SHORELINE SUBSTANTIAL DEVELOPMENT PERMIT EXEMPTION

The applicant is proposing the installation of a new septic system and drainfield.

File No. SX-25-00010

SCALE: ONE BOX = 10 FEET

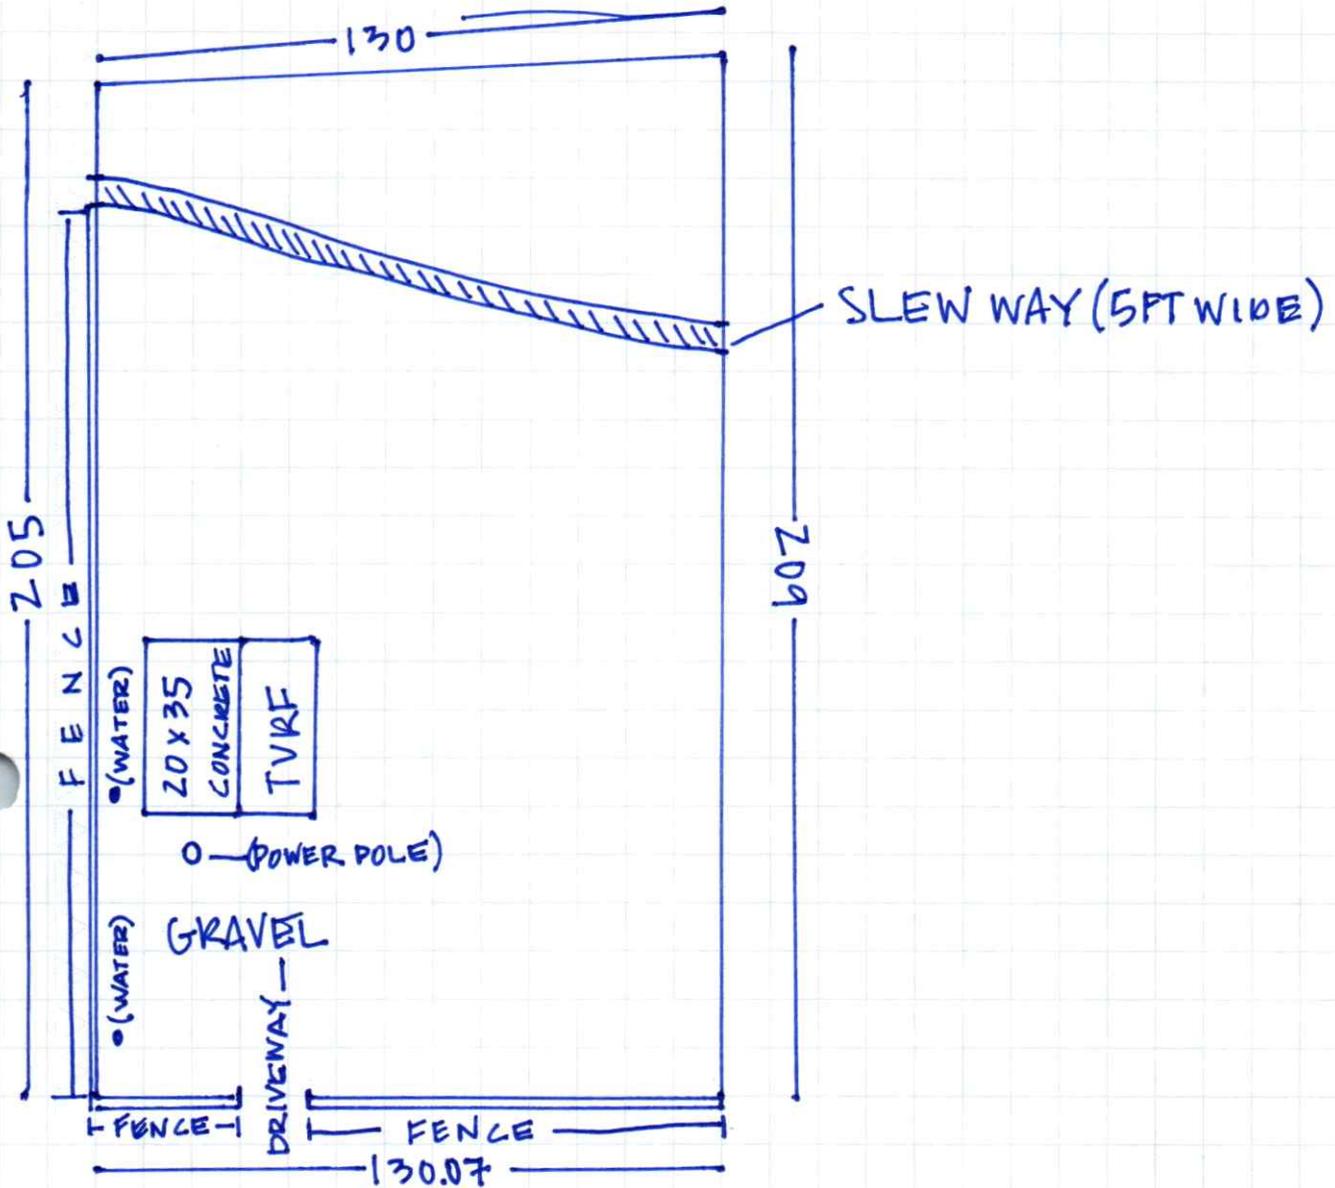
1. All work shall substantially conform to the specifications of the site plan and application materials submitted to Kittitas County Community Development Services by Rodney & Andrea Gott on July 23, 2025.

5. Site alterations shall maintain a 100-foot setback from any surface water. If unable to meet this requirement, a waiver may need to be completed. Contact Kittitas County Public Health for further information, if needed.

- The Development will comply with all applicable provisions of Kittitas County Code.
- All development shall take place outside the 115-foot buffer or more from the Ordinary High Water Mark.
